**KIRKLEES METROPOLITAN COUNCIL
INVESTMENT & REGENERATION SERVICE**

**DELEGATED DECISION TO DETERMINE APPLICATIONS FOR
NON-MATERIAL AMENDMENTS**

Reference No: 2021/NM/91191/E

Site Address: Zucchini, 260, Bradford Road, Batley, WF17 6JD

Ground Floor as Proposed
1:100

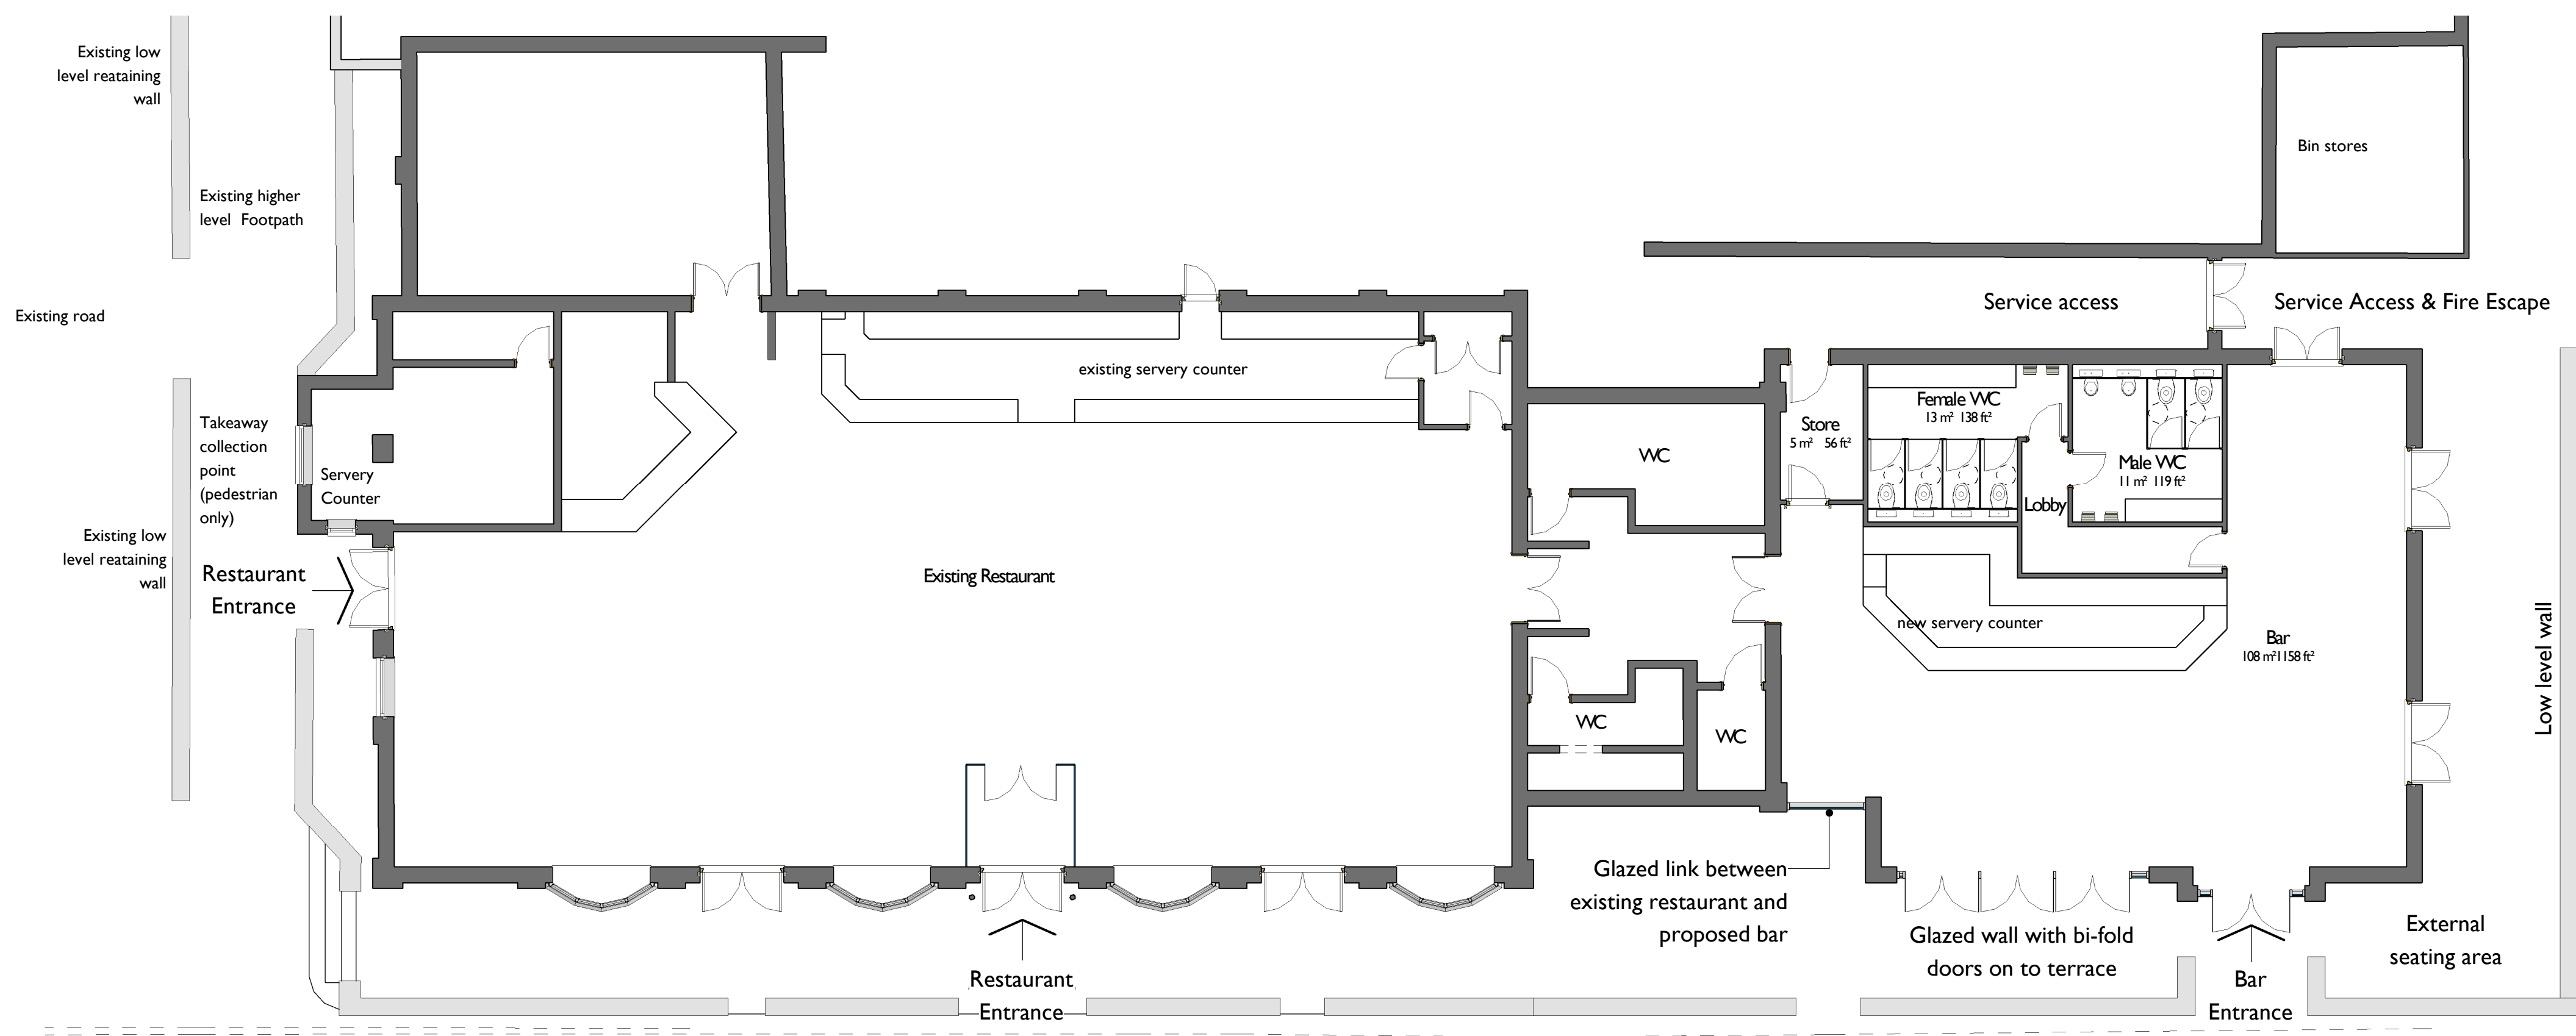
The alterations do not cause the proposal to fall out of the original application's description. However, they would result in a significant change to the appearance of the approved extension because of the large amount of glazing in the front and side elevations, as well as the use of grey coloured cladding. The impact on the overall appearance and design of this extension would be material and, therefore, would fail to meet the first test set out in the Protocol.

Due to the failure to comply with the first test, the proposed alterations could not be considered under the NMA procedure; this is irrespective of whether the subsequent tests 2, 3 and 4 could have been met. Also, to accept these changes would contravene condition 3 of the original permission, which requires that the extension be faced with white coloured render to match the host building.

Under those circumstances, a variation of condition application or a full application should be submitted if these amendments are to be incorporated
